Our ref: OUT22/10155

Subject: **Manildra - Port Kembla Bulk Liquid Terminal (SSD-33042483) – Environmental Impact Statement (EIS)**

### Detailed advice to DPE Planning & Assessment regarding the Manildra - Port Kembla Bulk Liquid Terminal (SSD-33042483)

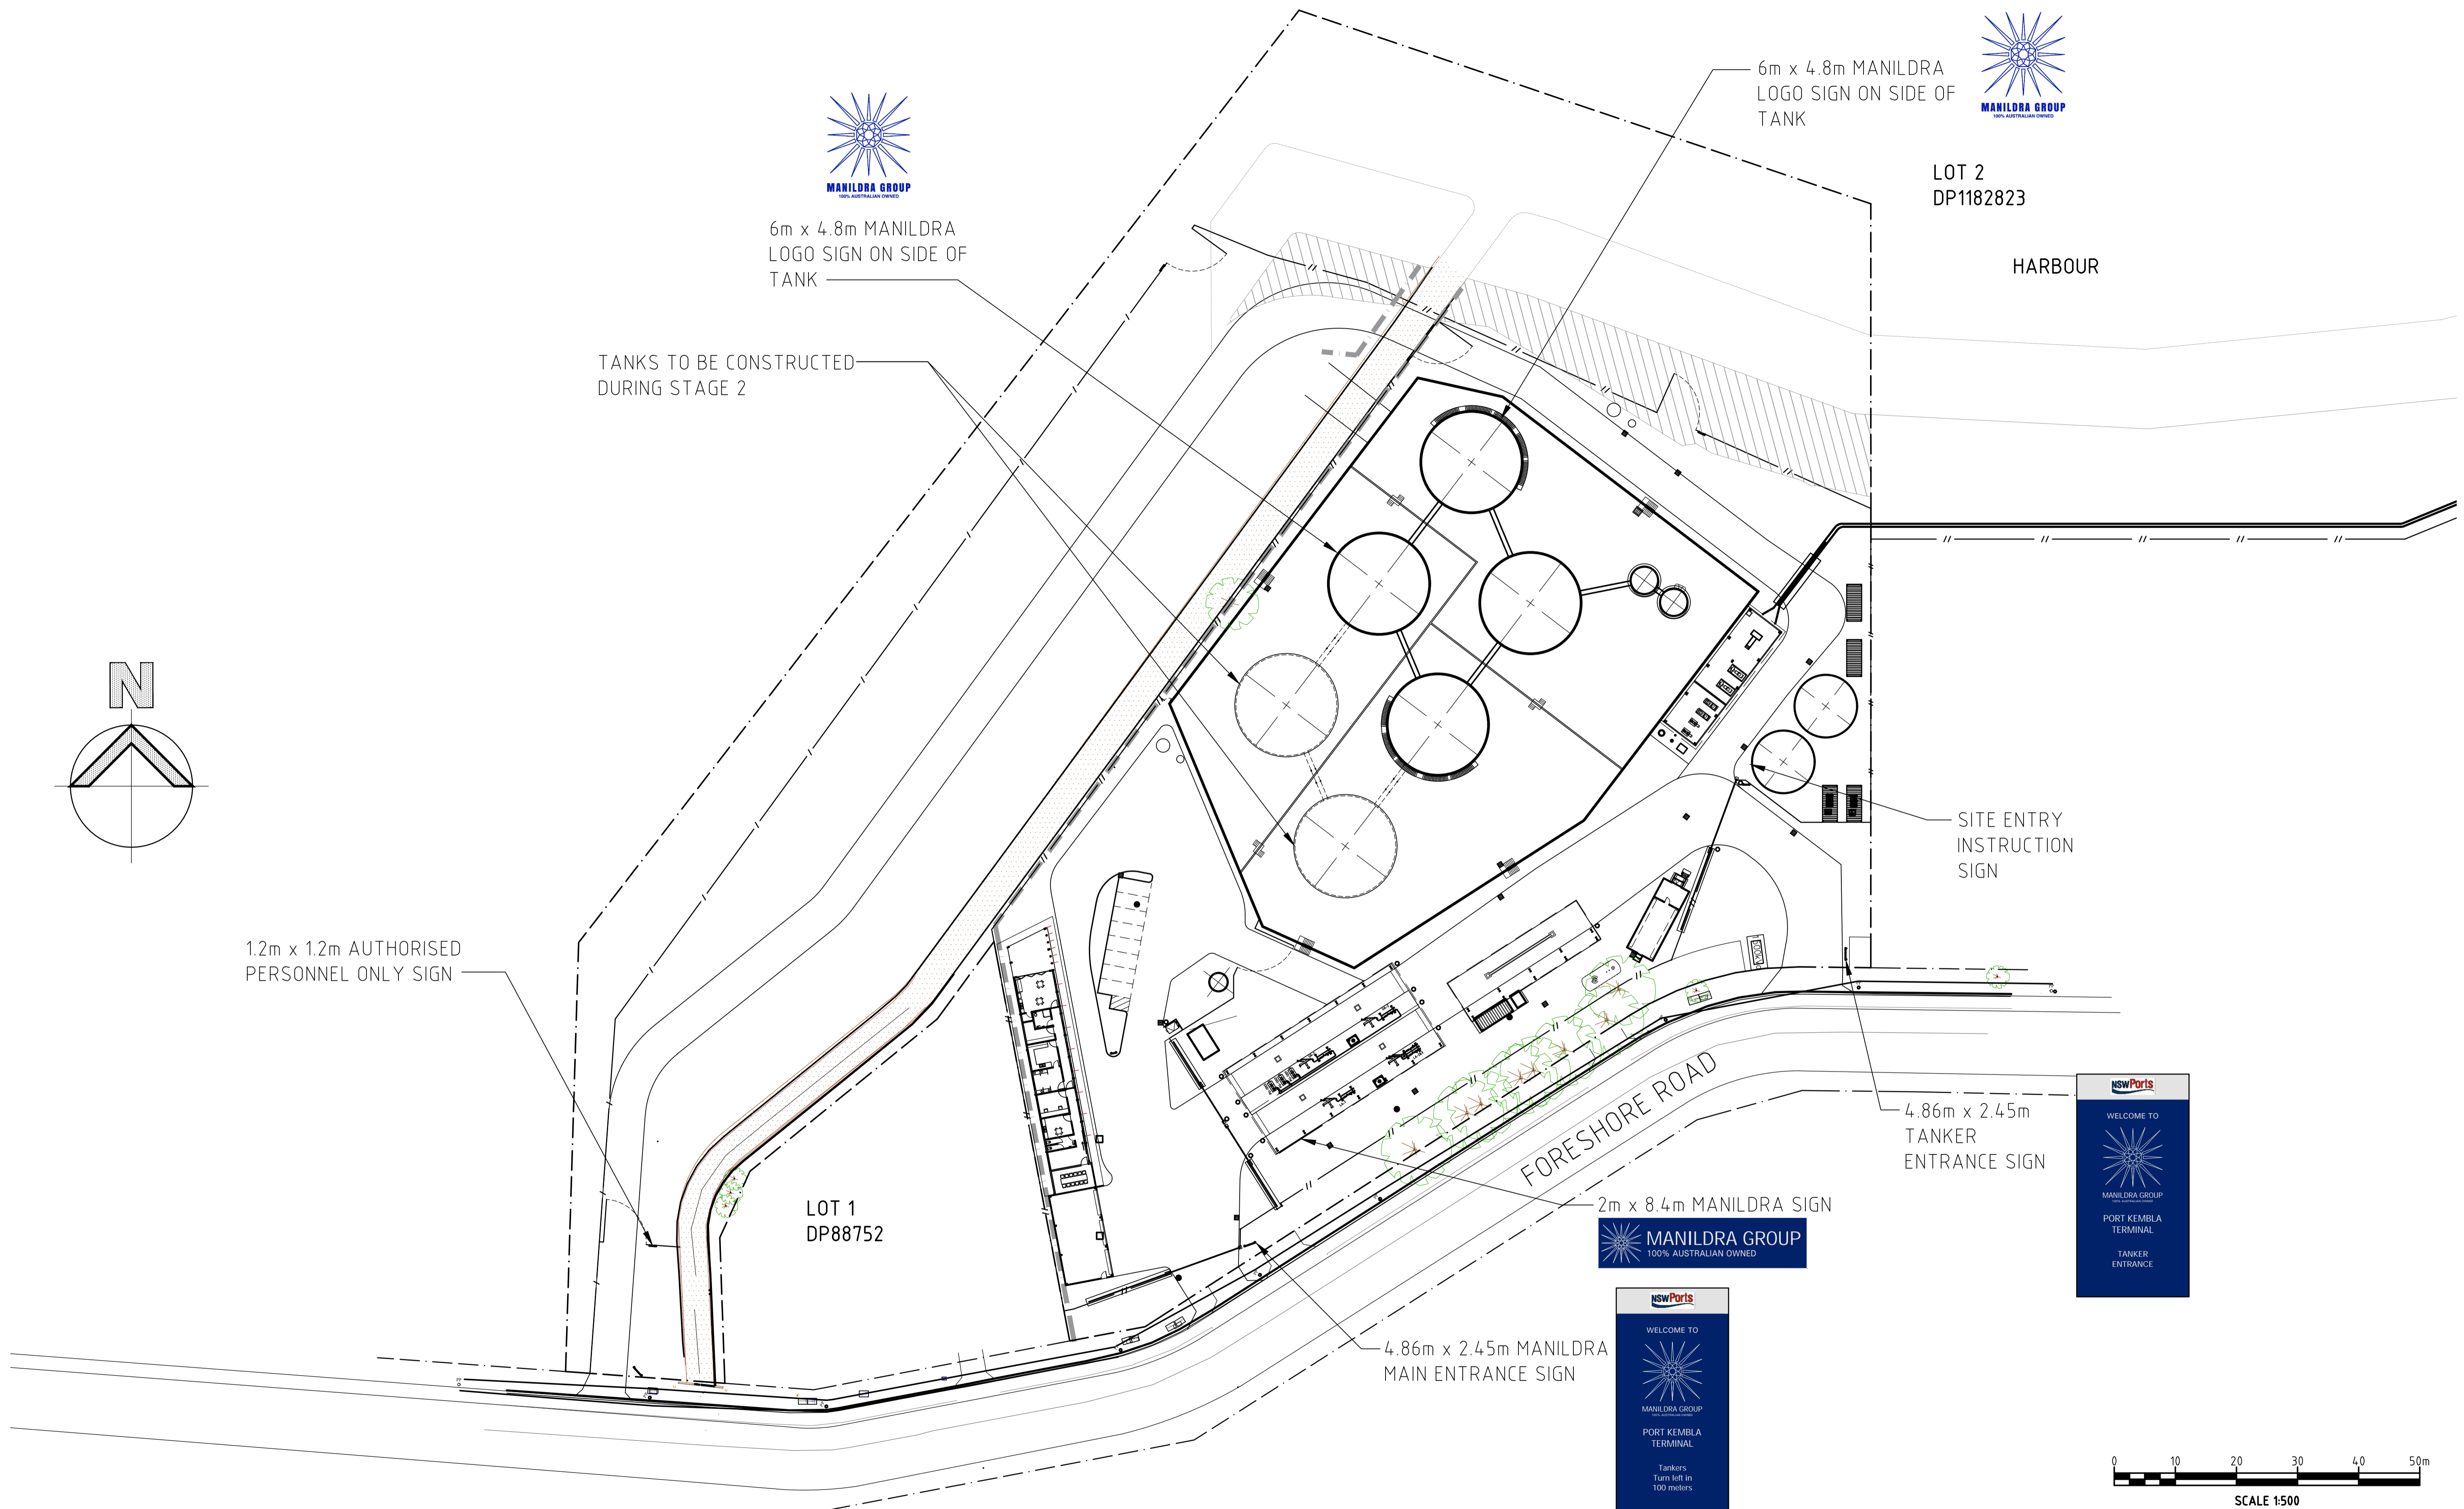
The proponent should demonstrate due consideration to the Guidelines for Controlled Activities on Waterfront Land in the design of the proposed crossing and stormwater outlets.

Construction plans for the project show stormwater outlets into Port Kembla Harbour, as well as the removal of a current bridge and construction of a new crossing. The plans mention scour protection for the outlets, but no details are provided. While the bridge is likely to have minimal impacts because it is located over a concrete-lined watercourse, it should not impede any flows as impediment could cause impacts due to the area being flood prone. It is noted that no design for the proposed new bridge has been provided.
